SUBJECT: WDFW COMMENTS ON SP-20-00004 HEIN APPLICATION

Thank you for the opportunity to comment on the SP-20-00004 Hein application concerning a proposed short plat on parcels #267336 and 107336. Washington Department of Fish and Wildlife (WDFW) has reviewed the application and supporting documents, including the stream report prepared by Sewall Wetland Consulting, Inc. Our comments surround conclusions made in the stream typing report.

AIRPORT ROAD SHORT PLAT APPLICATION

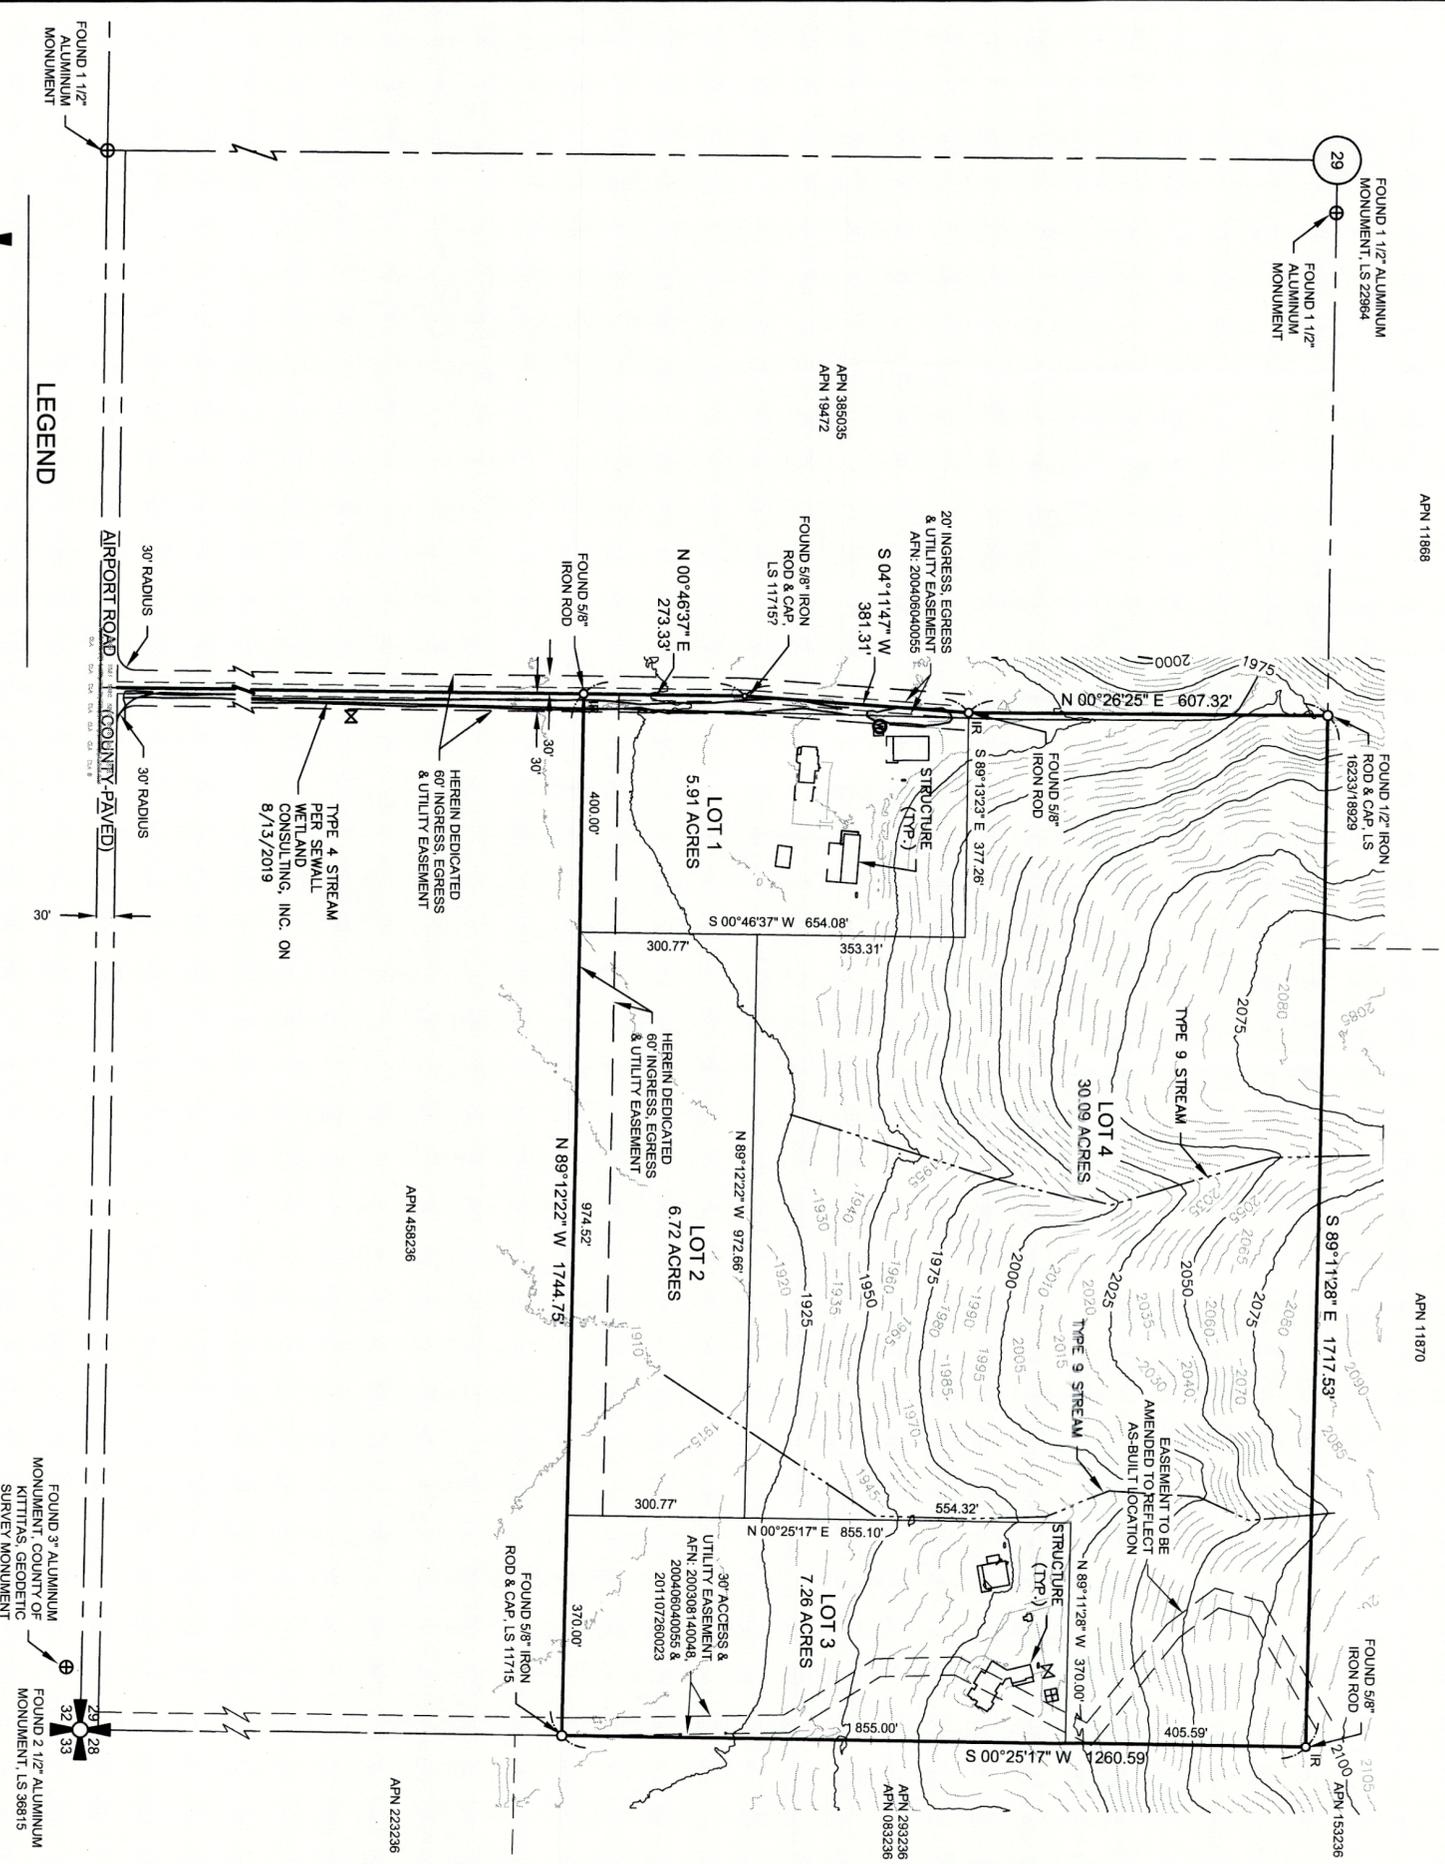
Further, while the report concludes there is no defined channel on the streams located on the hillside of the proposed Lot 4. These conclusions have not been field verified by WDFW nor any other agency of natural resource expertise to our knowledge. Prior to any building on Lot 4, a Forest Practice Application from Washington Department of Natural Resources is likely required, and the streams and slope stability would need to be reviewed under that application before any forest clearing could occur on Lot 4.
